**Exhibited EIS - Inland Rail Project - Parkes to Narromine**

I refer to your request dated 17 July 2017 seeking comment from the Office and Environment and Heritage (OEH) on the exhibited Environmental Impact Statement (EIS) for the Parkes to Narromine Inland Rail project. OEH understands that the proposed project will result in the clearing of 75.78 hectares of native vegetation across nine plant community types (PCTs), including the clearing of 63.07 hectares of threatened ecological communities (TECs). The biodiversity offset credit requirement has been calculated to be a total of 2,561 ecosystem credits and 491 species credits for the koala.

**ATTACHMENT A**

# Parkes to Narromine Inland Rail Project – Environmental Impact Statement

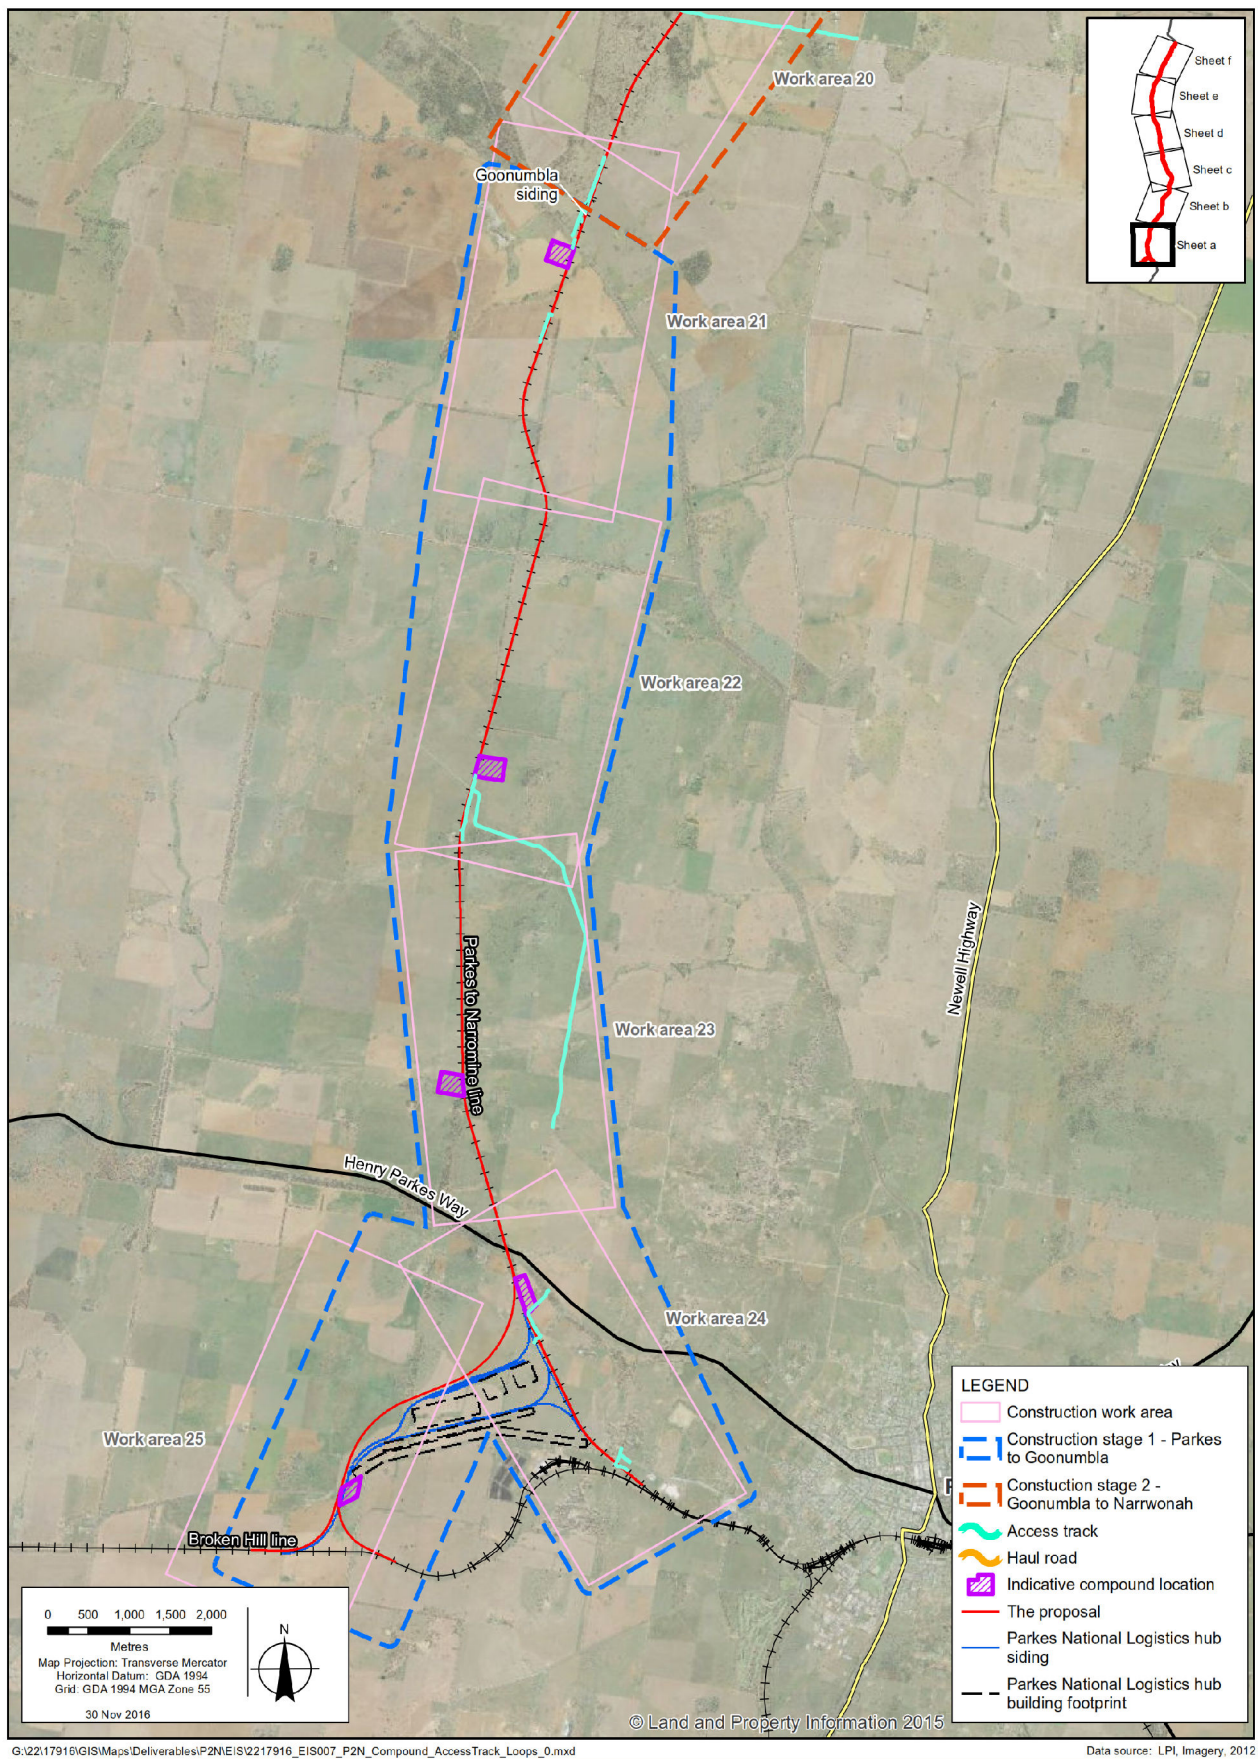
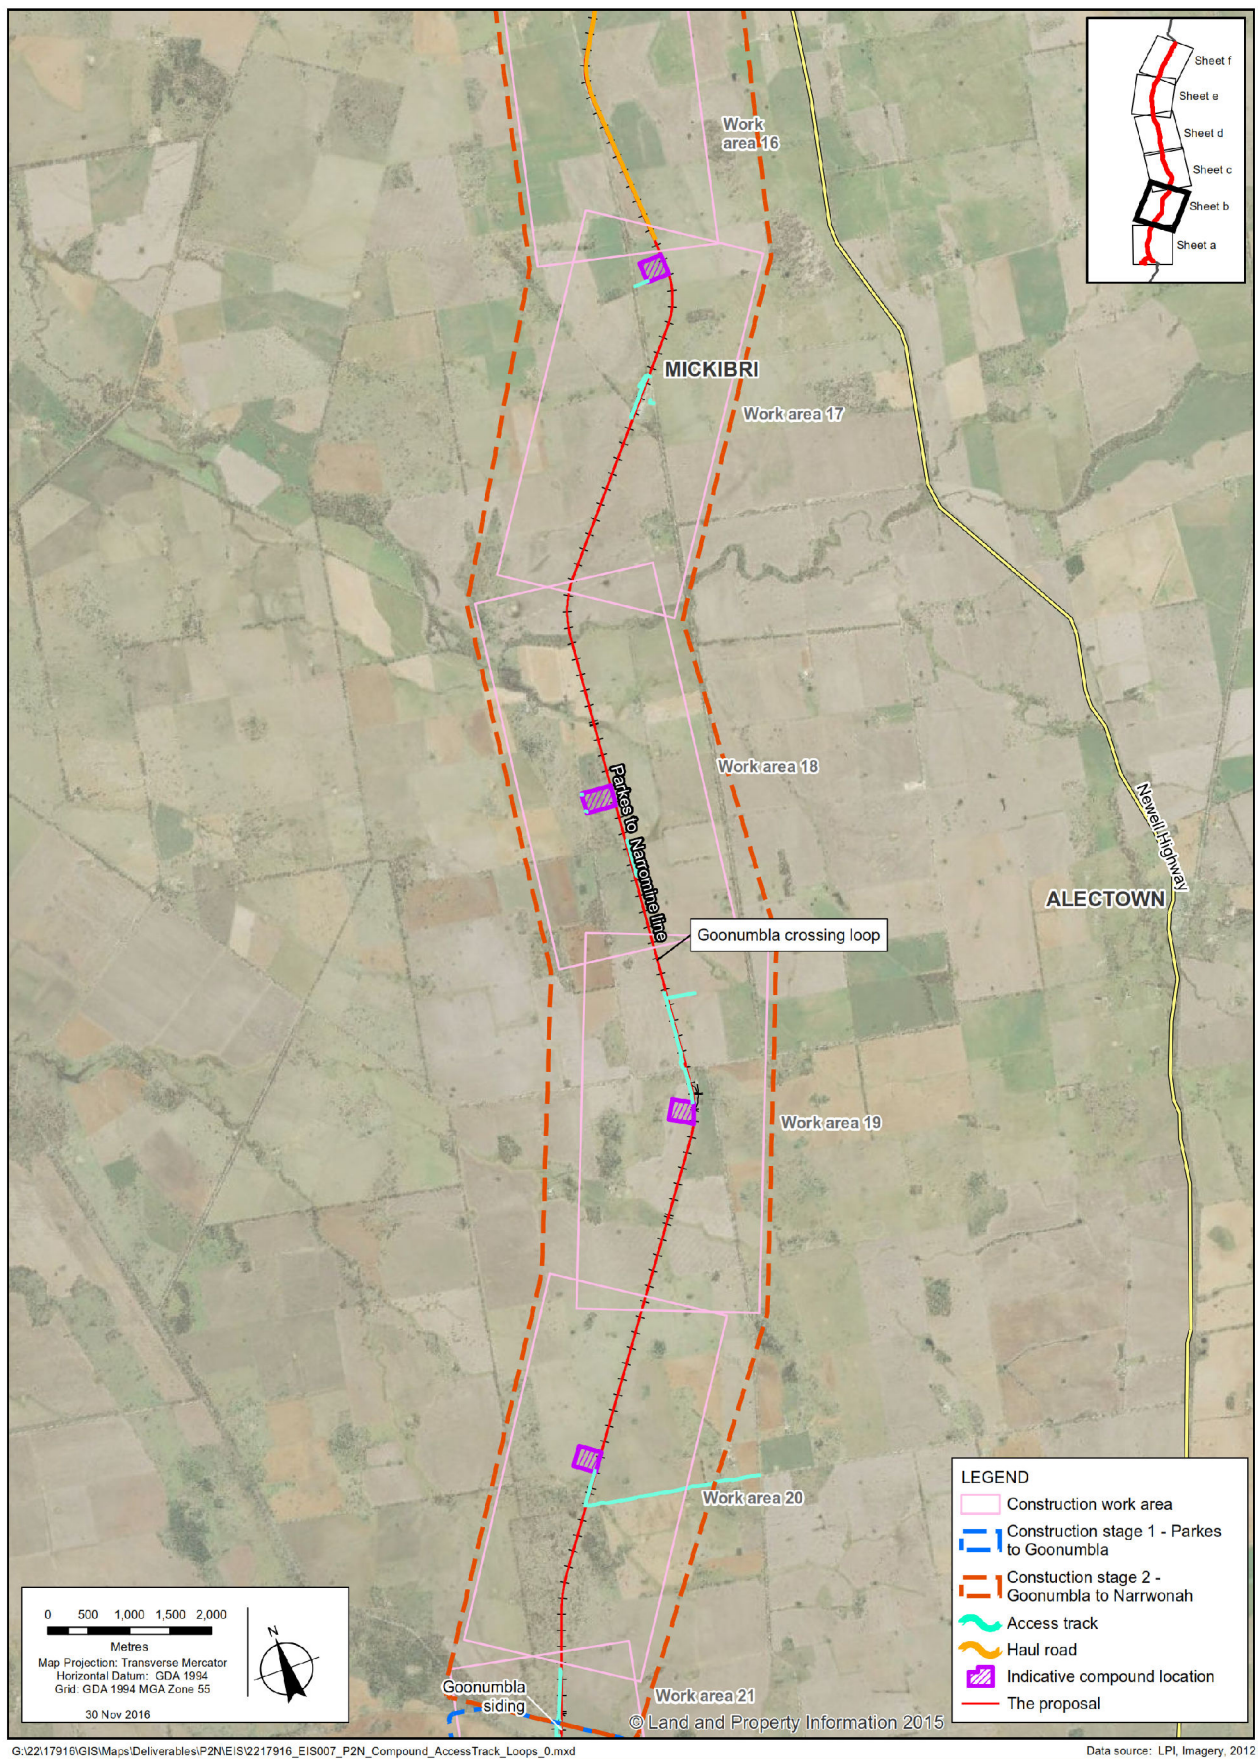
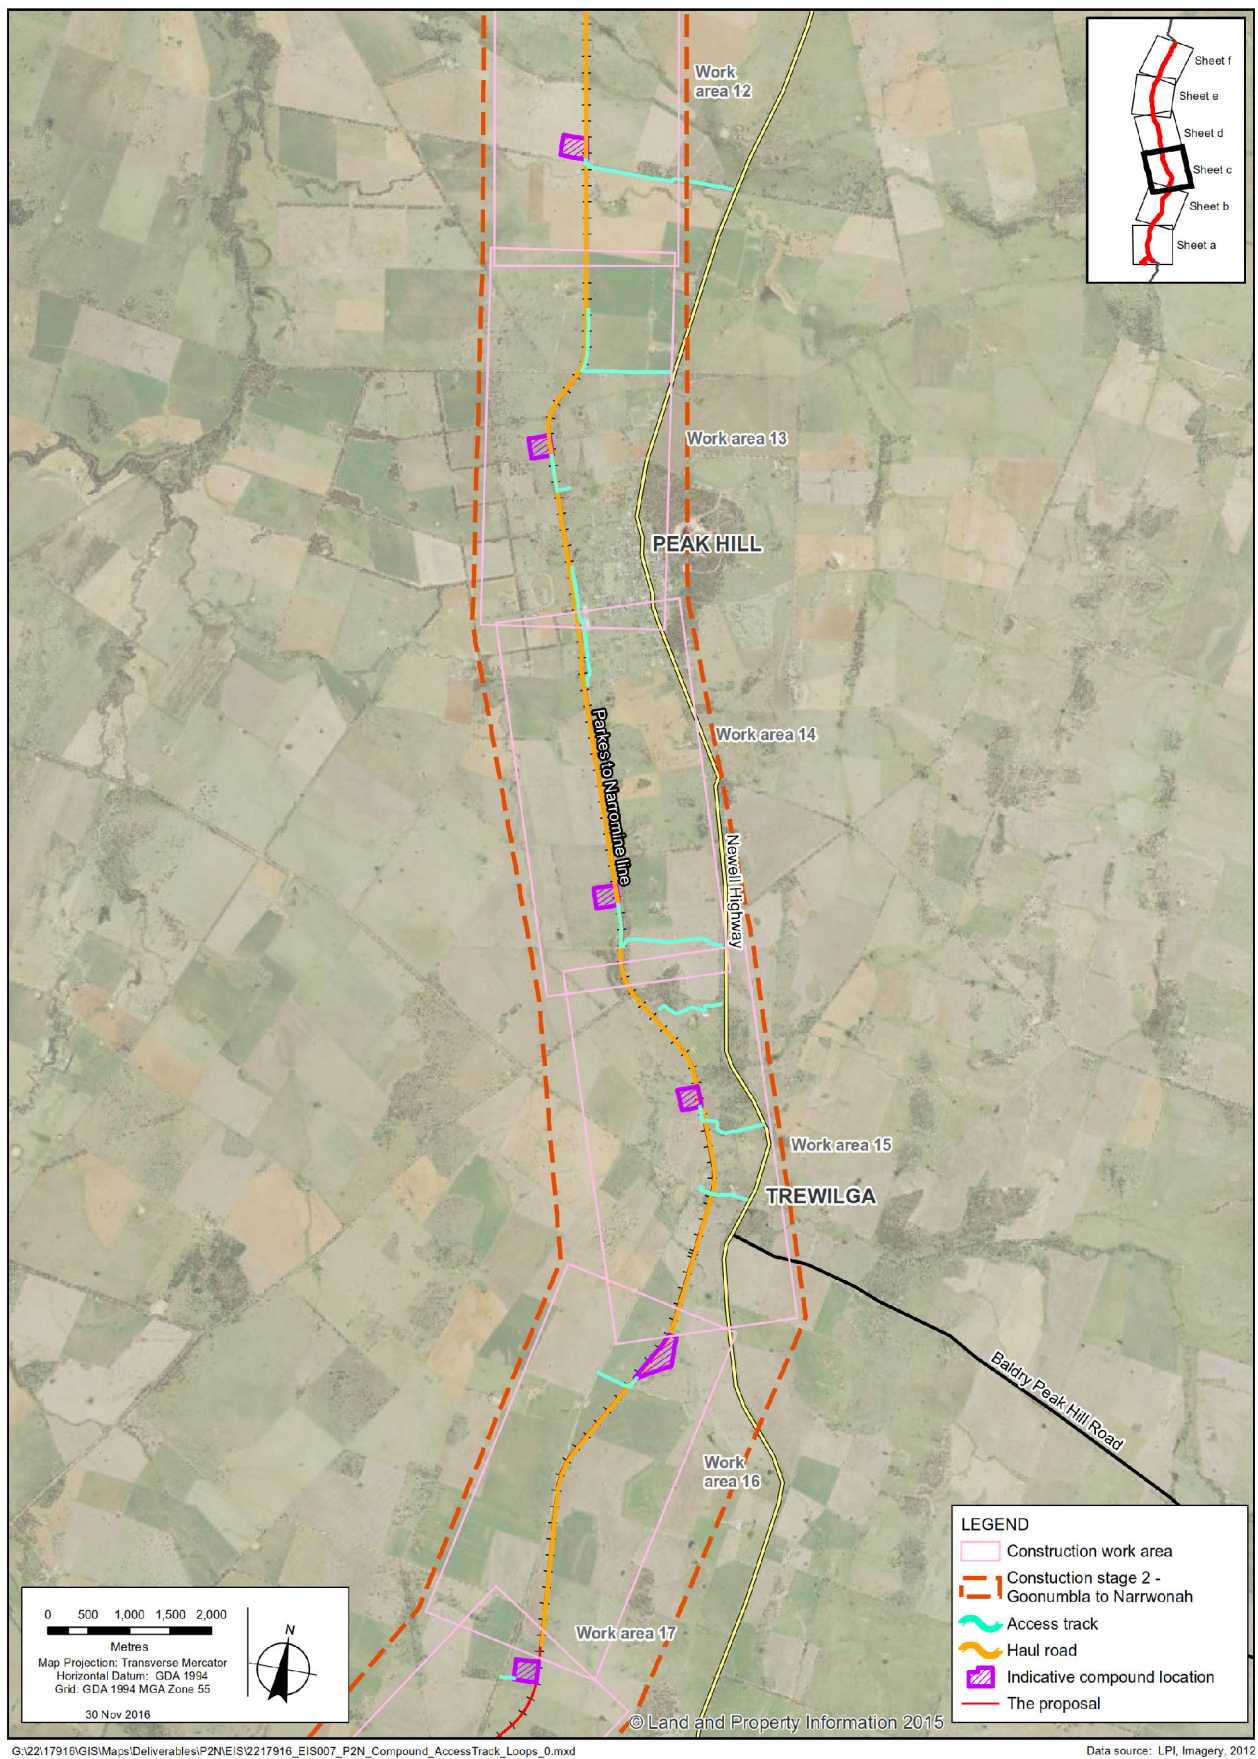
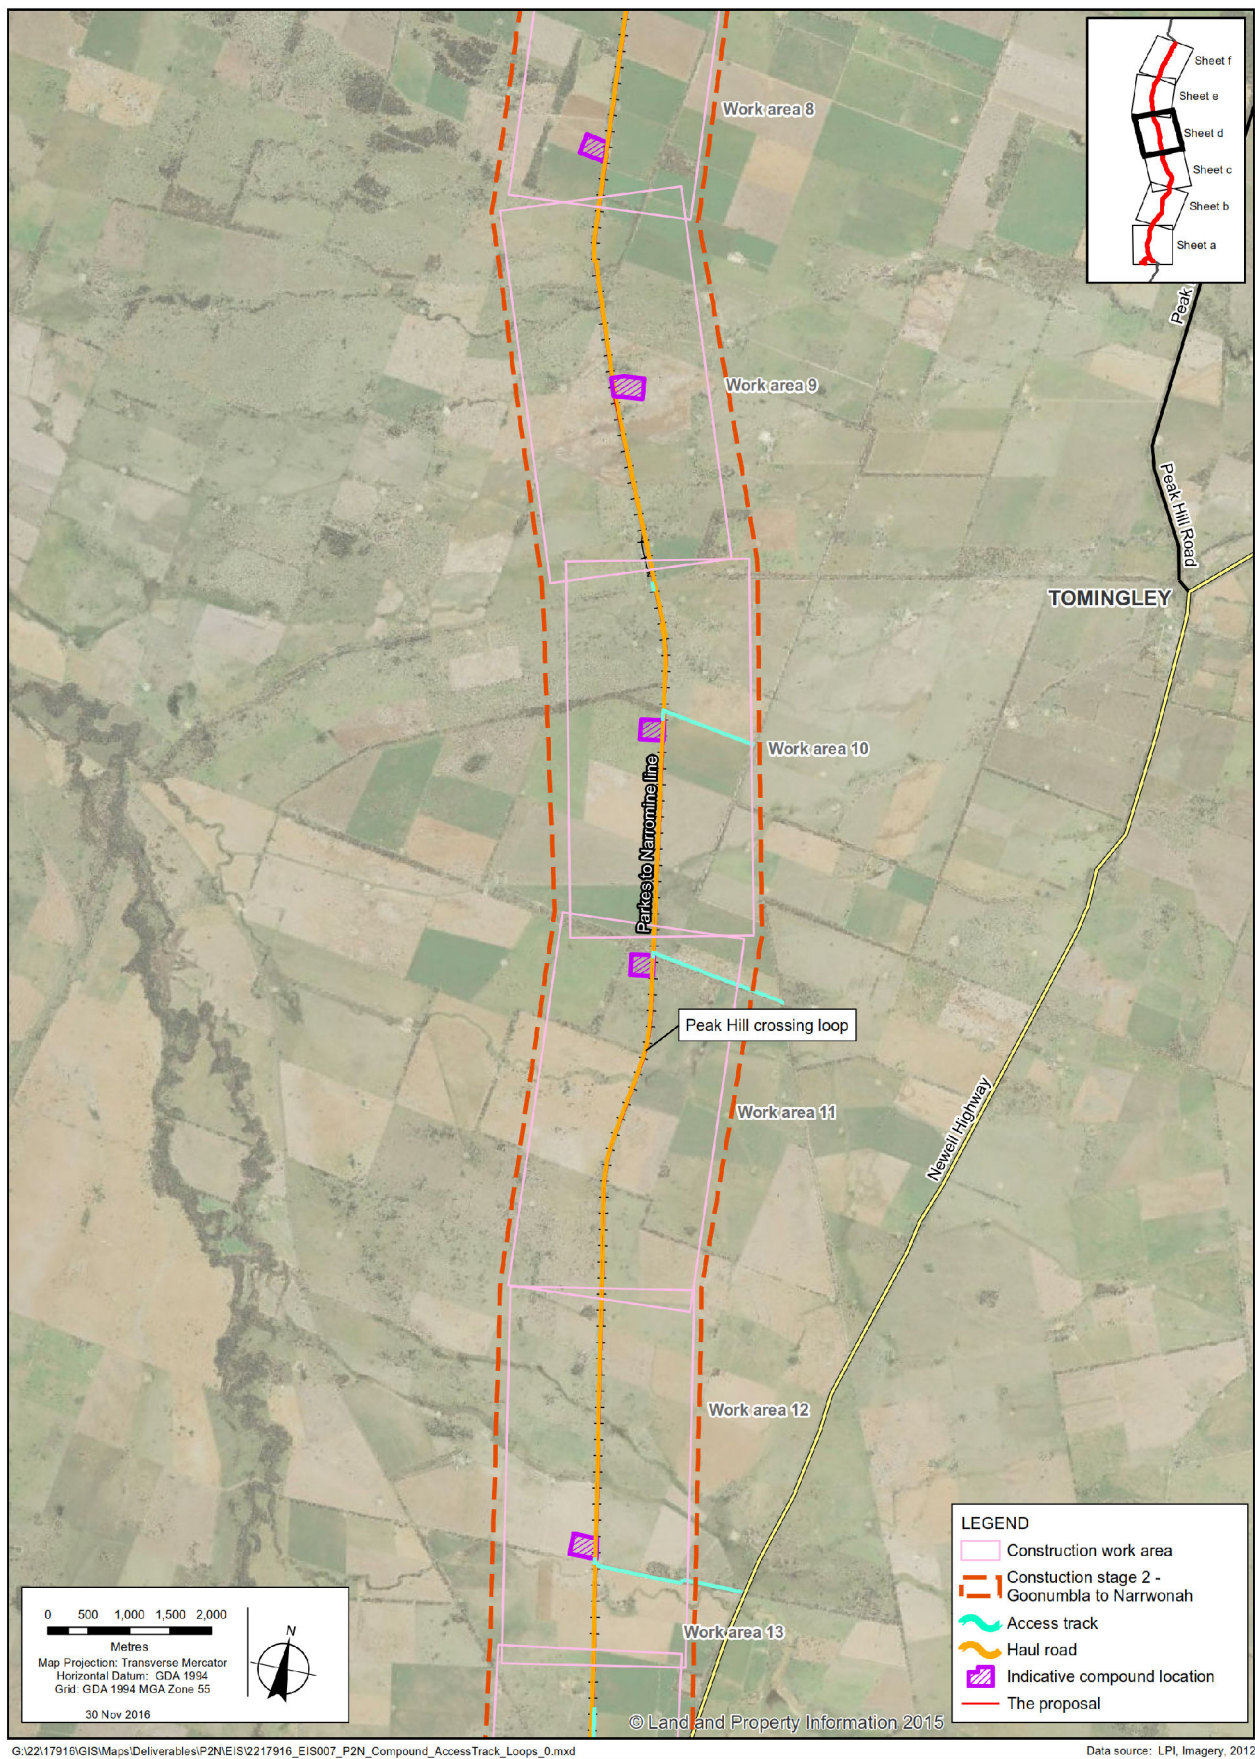
Most of the temporary impact zones identified in Figures 4.1A to 4.1E in the Biodiversity Assessment Report (BAR) are located within areas of non-native vegetation; thereby successfully avoiding impacts on biodiversity values. However, there are some compounds (in work areas 3, 11, 18 and 22 as displayed in Figures 8.2a-f in the main report) which are situated within areas of native vegetation, including threatened ecological communities (TECs). In each of these instances areas of non-native vegetation occur in close proximity, however no explanation has been provided as to why the compounds could not be re-located to these areas.

OEH understands that there may be some flexibility in the final location of the compounds. The proponent should make every attempt to avoid impacts on native vegetation and in particular TECs and threatened flora and fauna. Where these impacts cannot be avoided and are appropriately justified, the proponent will need to assess the impacts using the FBA and offset them with the corresponding biodiversity credit requirements.
